**KIRKLEES METROPOLITAN COUNCIL
INVESTMENT & REGENERATION SERVICE**

DELEGATED DECISION TO DETERMINE PLANNING APPLICATIONS

Reference No:	2022/62/91725/W
Site Address:	3, Holly Road, Thornton Lodge, Huddersfield, HD1 3SE
Description:	Erection of two storey rear extension and front dormer
Recommending Officer:	John Holmes

HOUSEHOLDER DELEGATED REPORT

Drawing 690-01
EXISTING & PROPOSED PLANS,
ELEVATIONS & LOCATION PLAN

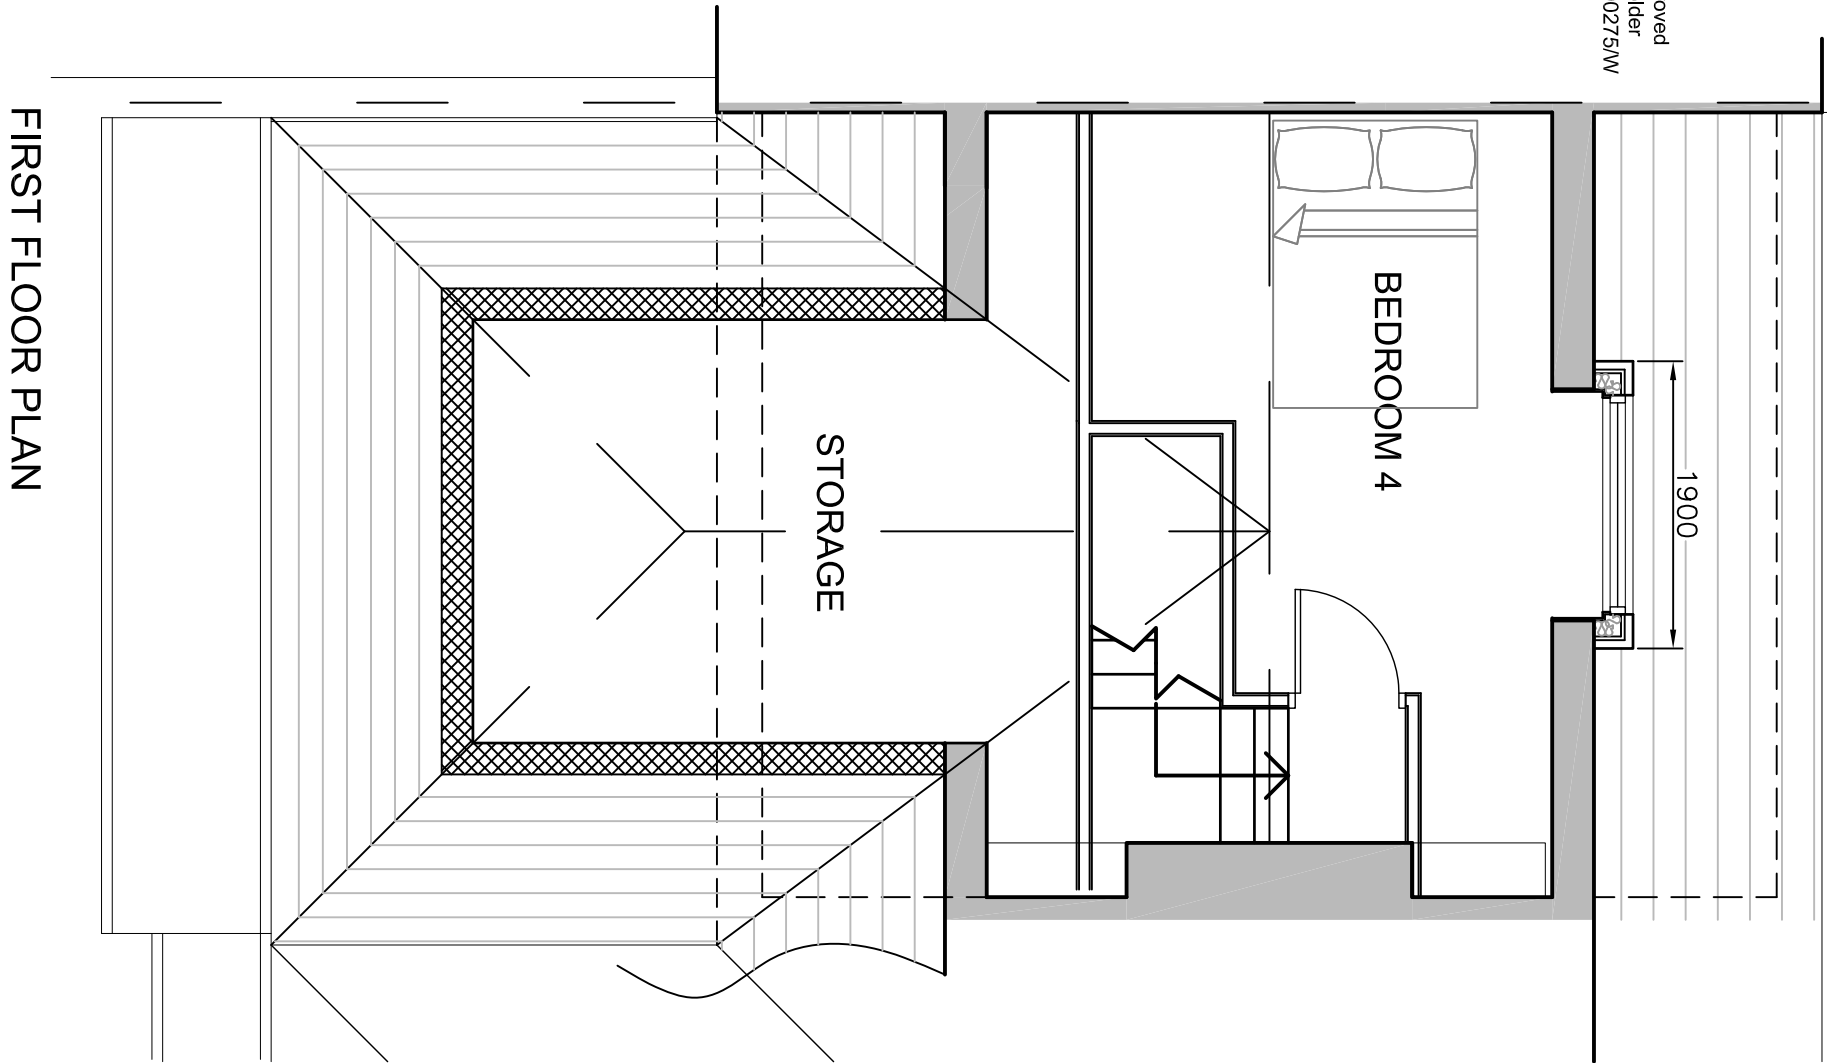
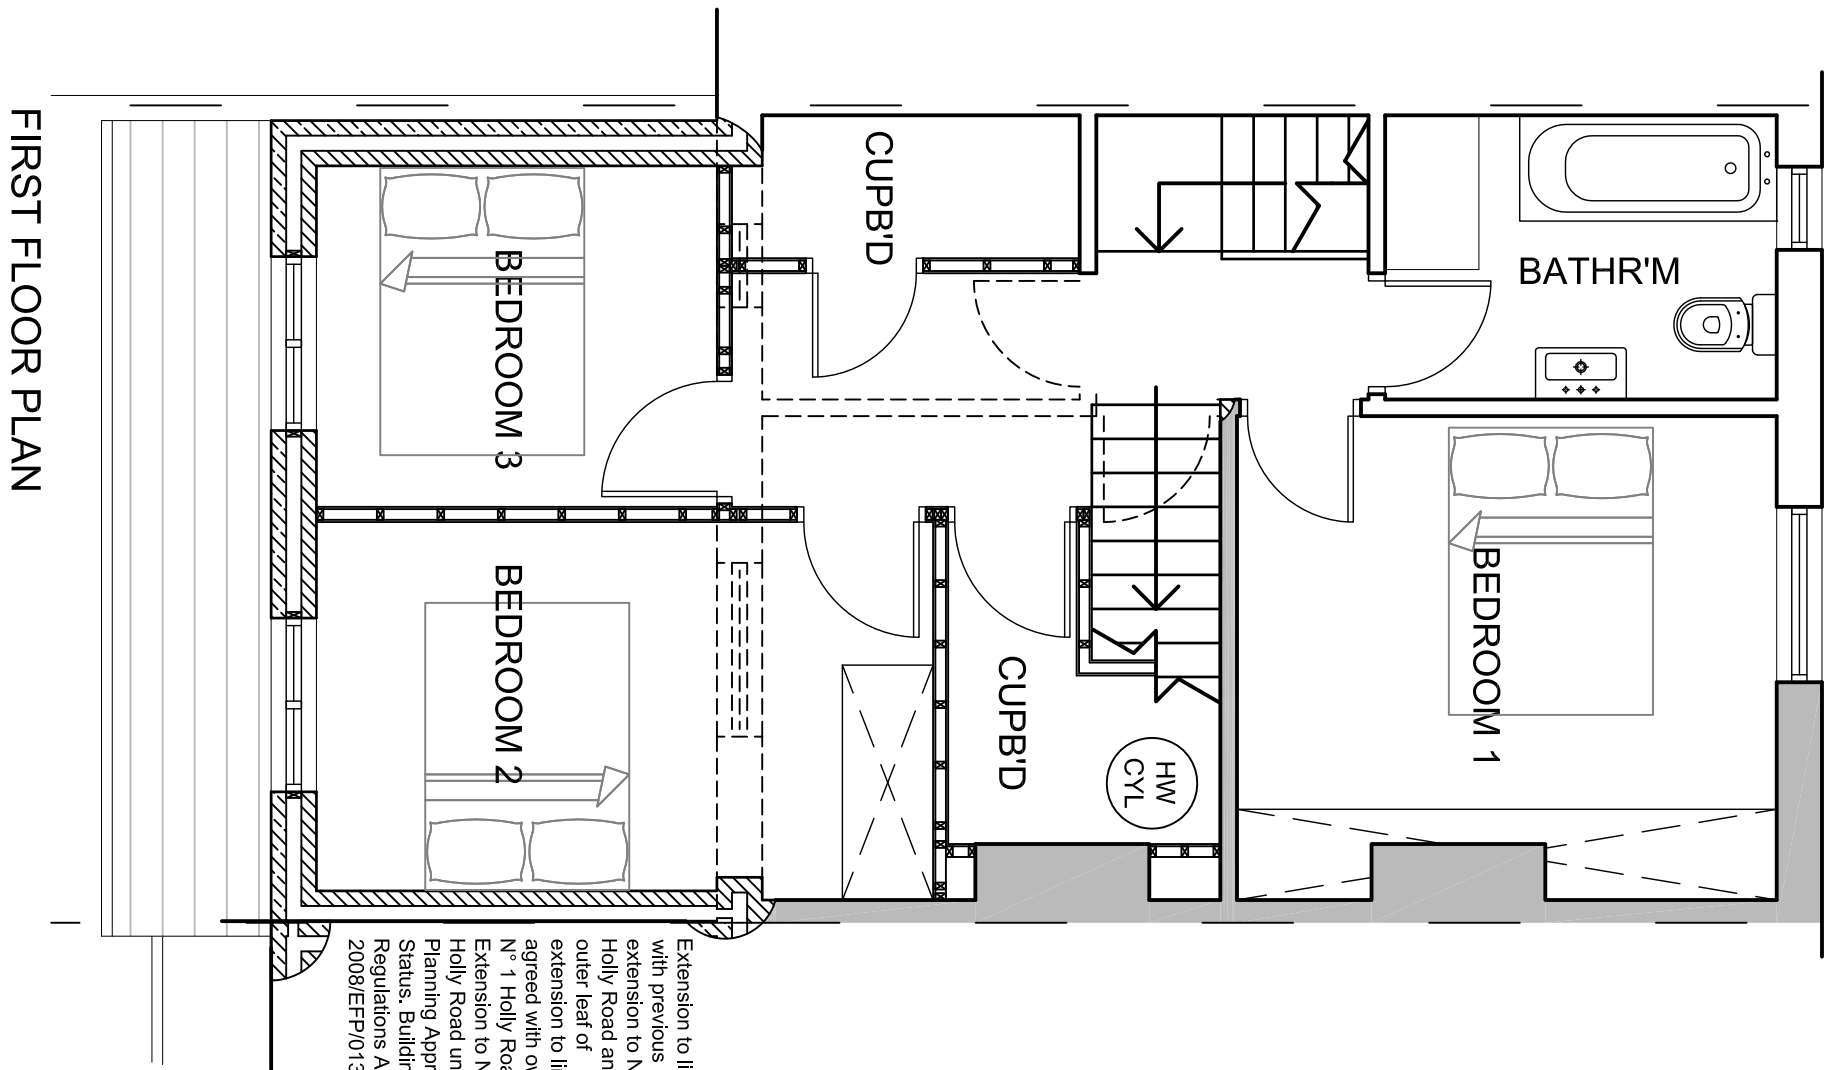
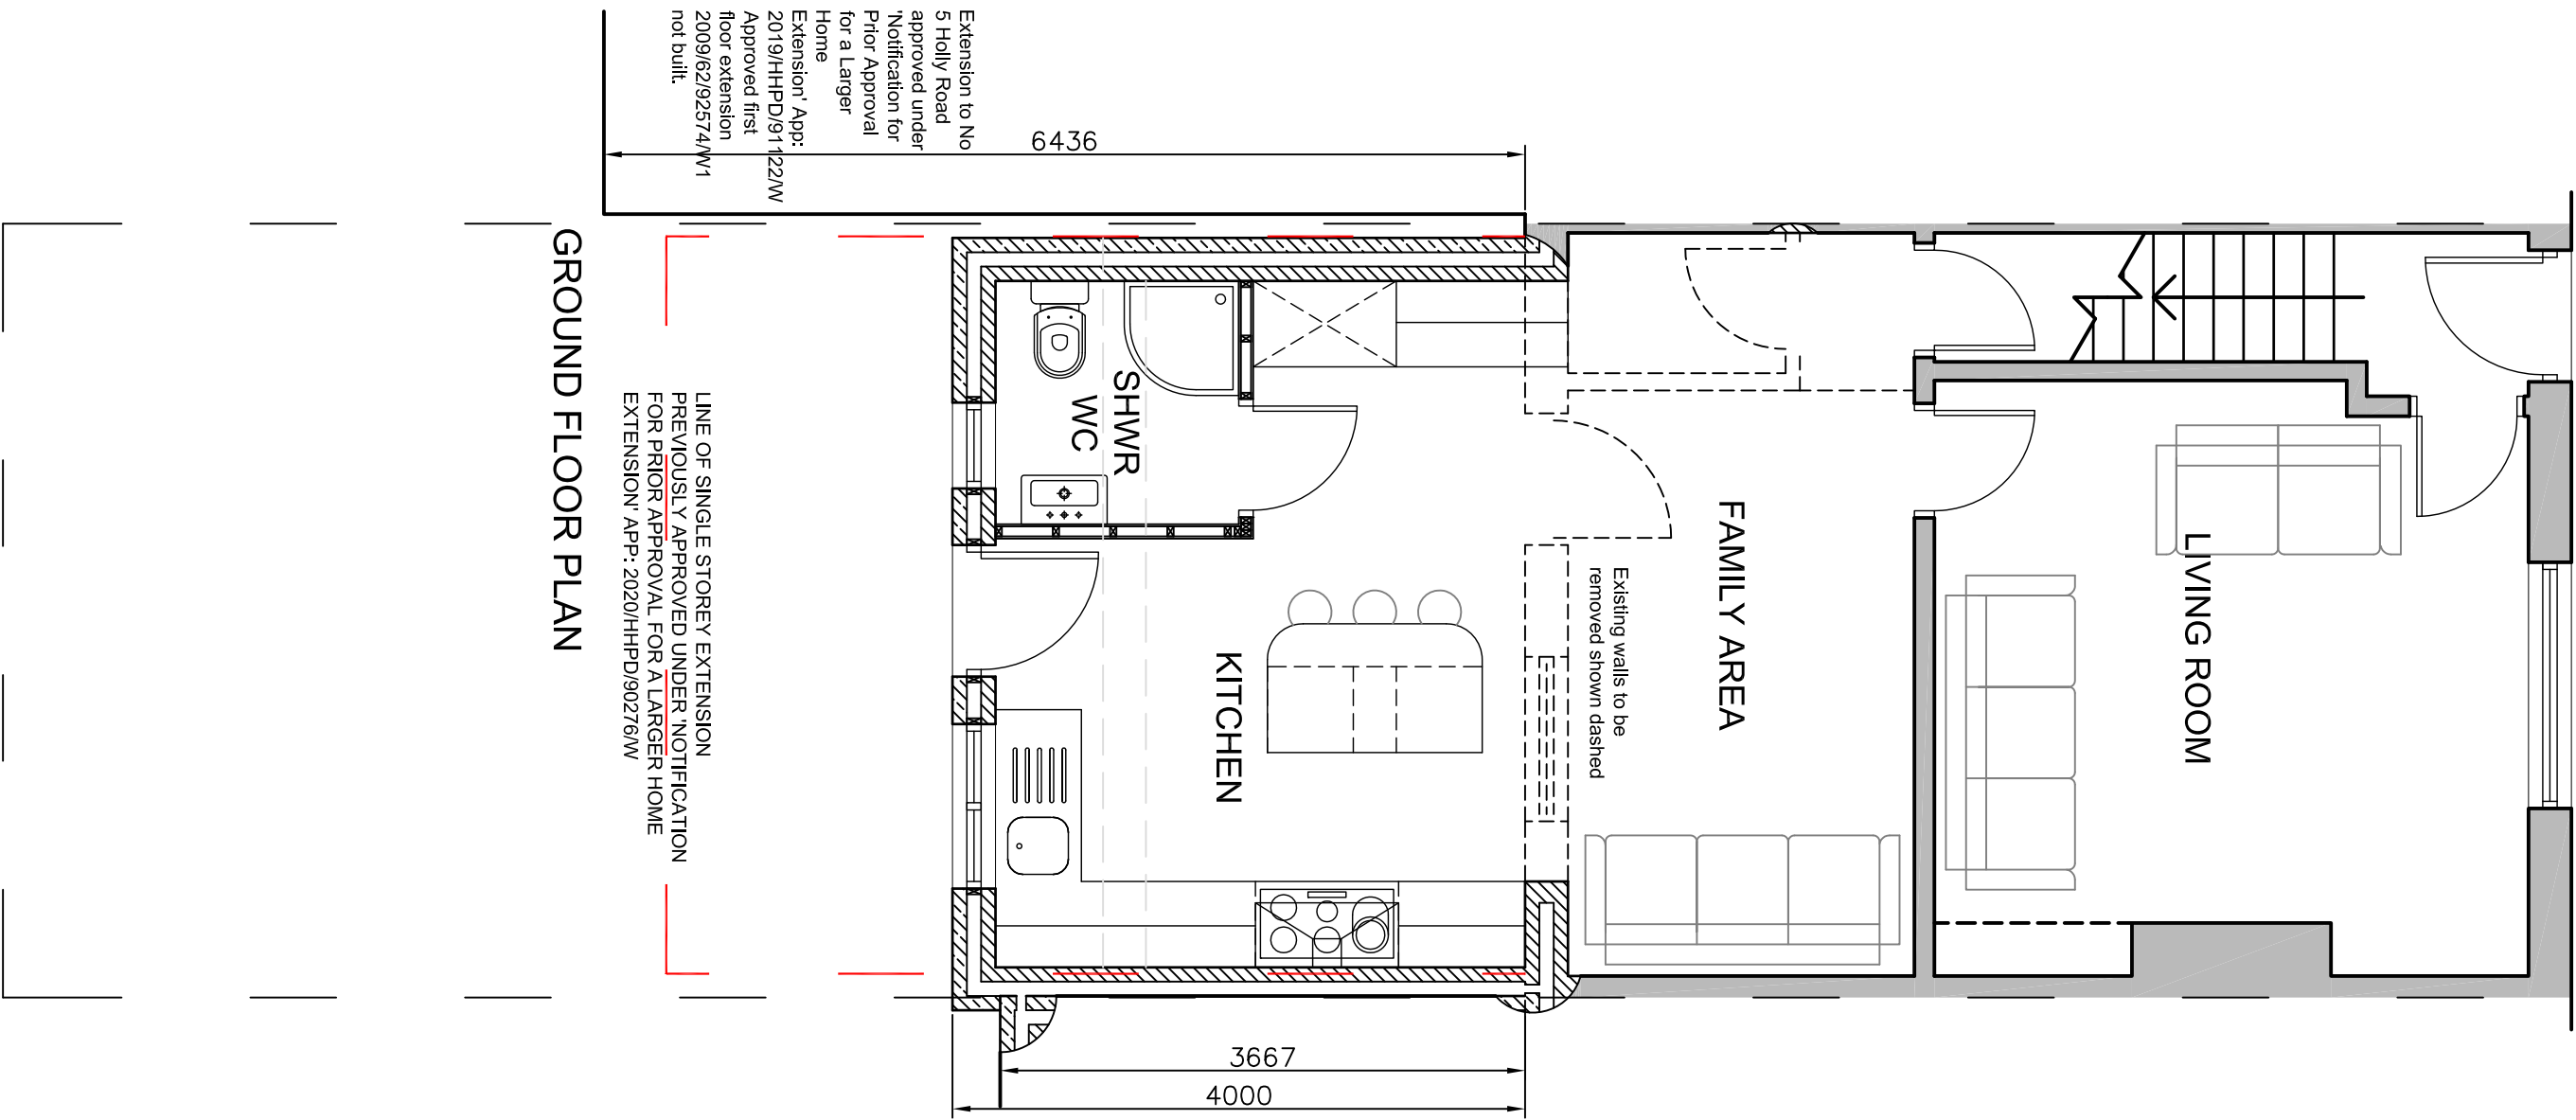
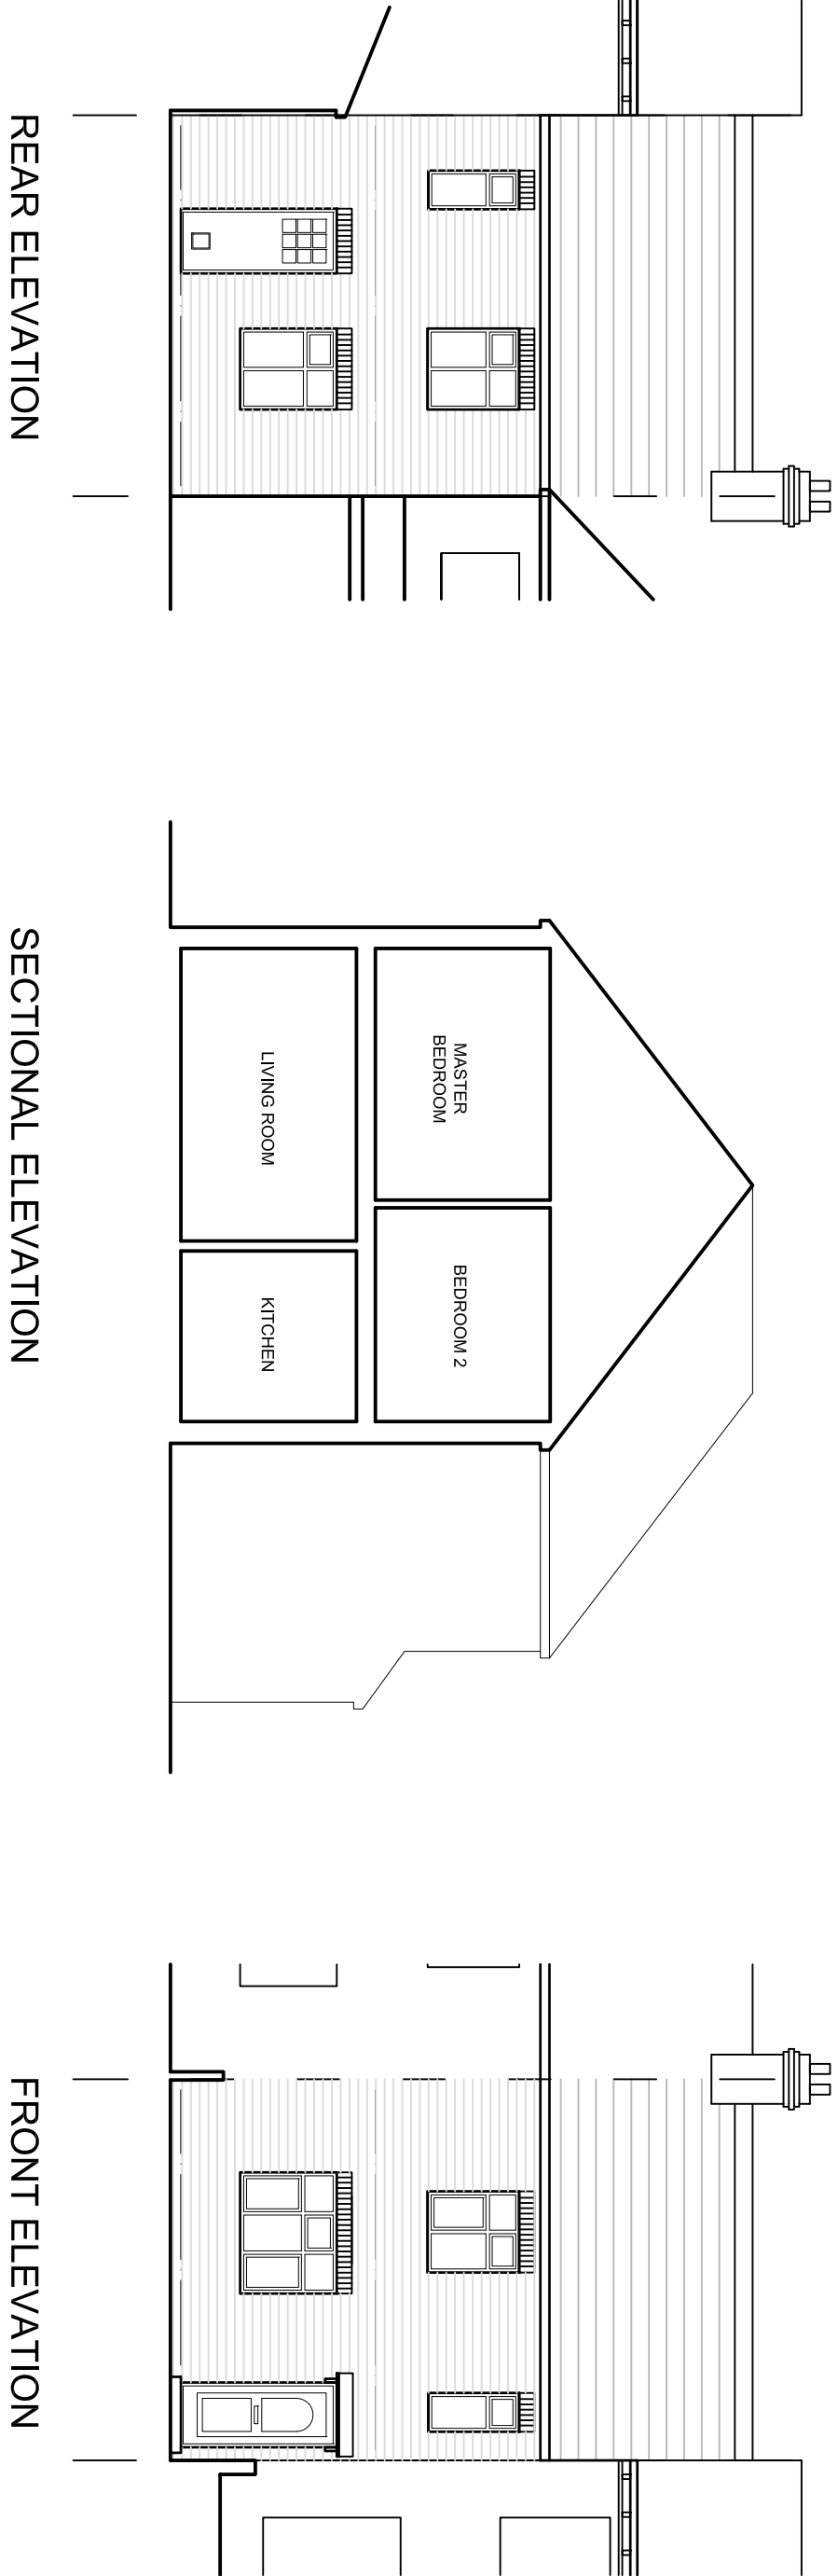
<u>Two Storey Rear Extensions should:</u>	<u>Yes - COMPLY</u>	<u>No - JUSTIFY</u>
be proportionate to the size of the original house and garden;		The extension is to the rear and although sizeable it is in keeping with the style, scale and design of an extension to the adjoining property (no.1) which is of an identical design.
not normally exceed 50% of the total area of land around the original house (including previous extensions and outbuildings);	The extension would not cover more than 50% of the amenity space serving the dwelling.	
not project out more than 3 metres from the rear wall of the original house or by 4 metres for detached properties;		The extension does exceed this at the ground floor level, although it is in keeping with the style, scale and design of an extension to the adjoining property.
not exceed a height at the eaves of 3 metres where the extension is within 1.5 metres of the property boundary;		The extension does exceed this although it is in keeping with the style, scale and design of an extension to the adjoining property.

be separated from the property boundary, such as a wall, fence or hedge, by at least 1.5 metre;		The extension does not achieve this although it is in keeping with the style, scale and design of an extension to the adjoining property.
not adversely affect habitable room windows where they adjoin a neighbour's boundary.	The extension is considered to meet this requirement.	
<u>Dormer windows should:</u>		
relate to the appearance of the house and existing roof	The dormer is set in from the sides, back from the eaves and below the

ridge of the host property. It is considered to acceptably relate to the appearance of the dwelling / roofslope.	
be designed in style and materials similar to the appearance of the existing house and roof	The dormer would be finished in a similar colour	
not dominate the roof or project above the ridge of the house	The dormer is considered to meet this requirement.	
be set below the ridgeline of the existing roof and within the roof plane	The dormer is considered to meet this requirement.	
be aligned with existing dormer windows on neighbouring properties in the same roof plane where relevant	The scale of the dormer and its siting in the roof slope is similar to that of an extant consent for the adjoining property which could still be implemented.

Relevant key design principle (KDP) of the SPD, Policy in the Kirklees Local Plan and the NPPF	Further comments	✓ / X / N/A
Impact on the Local character and street scene	- KDP1 of the SPD - Policy LP24 Design (a) and (c) of the KLP	The two storey rear extension is visible from the highway to the east of the site, although will be in keeping given the adjoining property's extension to rear	✓

Chapter 12 NPPF	(no.1) which the proposal would be of a similar design. The dormer to front would be of a similar design to that of an extant consent in place at the host property and adjoining property. The impact is concluded to be acceptable.	
Impact on original house	- KDP2 of the SPD - Policy LP24 Design (c) and (d) of the KLP - Chapter 12 of the NPPF	The proposal would not significantly erode the character of the original dwelling and is considered acceptable in this regard. This takes into account the quantum of development to no. 1	✓
Height, scale and massing	- KDP 1 and 2 of the SPD - Policy LP24 Design (a), (c) and (d) of the KLP - Chapter 12 of the NPPF	The height, scale and massing of the development is considered to be in keeping to the host dwelling taking account of previously implemented development to the adjoining dwelling at no. 1 of which the host property forms a pair	✓

Facing materials and detailing	- KDP 9 of the SPD - Policy LP24 Design (d) (iii) of the KLP - Chapter 12 of the NPPF	The materials would harmonise with the materials palette of the original dwelling. This would be brick and tile to match the existing and dark cladding to the dormer	
Roof style	- KDP 1 and 2 of the SPD - Policy LP24 Design (a), (c) and (d) of the KLP - Chapter 12 of the NPPF	This is considered to be in keeping with that of the adjoining dwelling and as such is considered to be acceptable in this case. The dormer would harmonise with that at no. 1	✓
Window proportions	- KDP 1 and 2 of the SPD - Policy LP24 Design (a), (c) and (d) of the KLP - Chapter 12 of the NPPF	These are considered to be in keeping with the locality and host property.	✓
Accessibility for all users	KDP 17 of the SPD	The proposal would be suitably accessible.	✓

Relevant key design principle (KDP) of the SPD, Policy in the Kirklees Local Plan and the NPPF	Further comments	✓ / X / N/A
Impact on privacy of neighbours (to sides, rear and front)	• KDP 3 & 4 of the SPD • Policy LP24 Design (d) (iv) • Chapter 12 of the NPPF	No openings in the side that would face 1 & 5 Holly Road. Openings to the rear would be nearer 42, 44 & 50 Yew Hill Road maintaining a distance of 19.5m at ground floor and 20.5m at first floor. This is in keeping with the existing arrangements in the locality and considered acceptable. The dormer to front is set back from the front elevation of the host property and is not considered to significantly increase overlooking over and above that which exists already in relation to properties opposite (4, 6, 12, 14 – 16 Holly Road)	✓
Impact on light and outlook of neighbours (to sides, rear and front)	• KDP 4, 5, 6 of the SPD • Policy LP24 Design (b) • Chapter 12 of the NPPF	No significant impact given distance from neighbours and fact no.s 1 & 5 Holly Road have large additions (ground floor only for no.5) and also the location of the window at first floor level to the rear of no.5.	✓

4. The cladding to the dormer hereby approved shall be dark grey. The cladding shall be applied to the dormer before the accommodation it serves is first brought into use. The cladding shall be retained as such thereafter.
